City of Portland, Maine - Building or Use Permit Application

has permission to **Reopening existing required exit stair from Edgcomb Potters (1st floor) to Market Street**

Proposed Use: Same - lower level café/bookstore & 1st floor retail	Proposed Project Description: Reopening existing required exit stair from Edgecomb Potters (1st floor) to Market Street
--	---

A-1.0 SITE PLAN

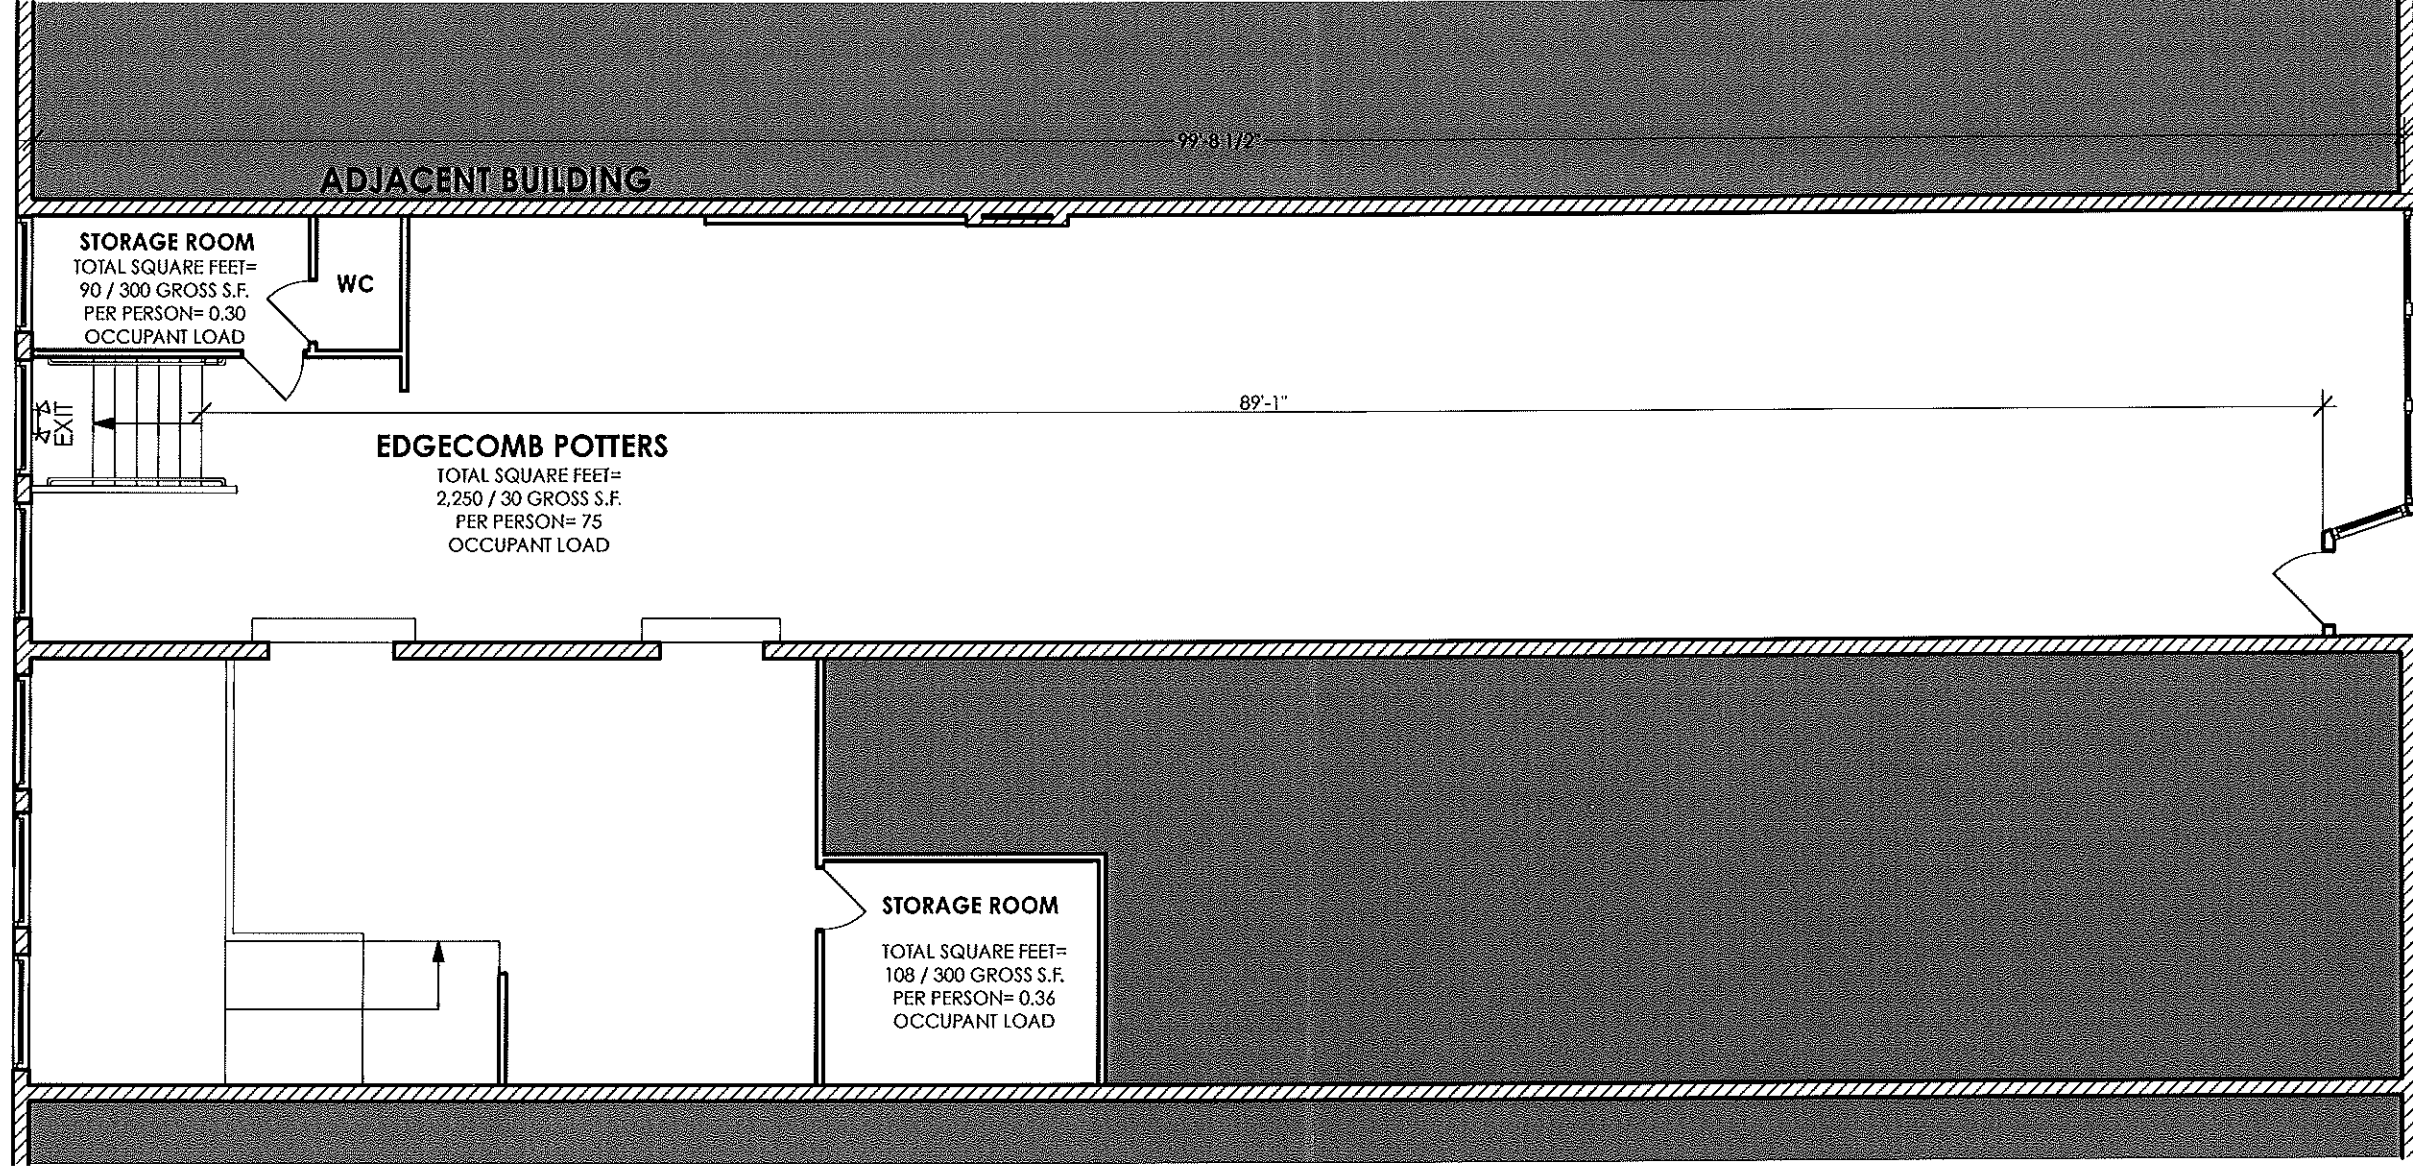
Dept: Building	Status: Approved w/Conditions	Reviewer: Jon Rioux	Approval Date: 03/27/2013
Note:			Ok to Issue: <input checked="" type="checkbox"/>
1) This permit re-opens an existing stairwell which was made (framed-in) inaccessible without benefit of a building permit.			
Note: The minimum egress widths for the components of the means of egress shall be based on the means of egress width factors in the building code under which the building was constructed. The re-opening of the stairwell includes the addition of a second handrail (one on each side), and fall protection.

3) 1009.4.4 Dimensional uniformity. Stair treads and risers shall be of uniform size and shape. The tolerance between the largest and smallest riser height or between the largest and smallest tread depth shall not exceed 3/8 inch in any flight of stairs. The greatest winder tread depth at the walkline within any flight of stairs shall not exceed the smallest by more than 3/8 inch.

Dept: Fire	Status: Approved w/Conditions	Reviewer: Ben Wallace Jr	Approval Date: 04/03/2013
Note:			Ok to Issue: <input checked="" type="checkbox"/>
1) The gaurds and handrails shall me new requirements per NFPA 101, Life Safety Code.			
2) All new features of construction shall comply with City Code Chapter 10.			
3) A fire alarm pull station, exit sign and emergency light shall be installed at the exit.

- 1) A building permit is required to reopen the Market Street exit from Edgecomb Potters. The Café permit may be issued once the exit permit is applied for. Suggest you can work with Darren's architect to provide the drawings you need to apply for the permit in as timely a manner as you can. They scope of work must indicate that you're reopening the rear exit using an existing stair that was previously floored over. Scalable drawings must include:

- a) A stair detail showing the rise, run and width of the existing stair and the new guard and handrails to be installed on both sides of the stair.
 - b) The new fire alarm pull station, exit sign and emergency light to be installed at the exit.
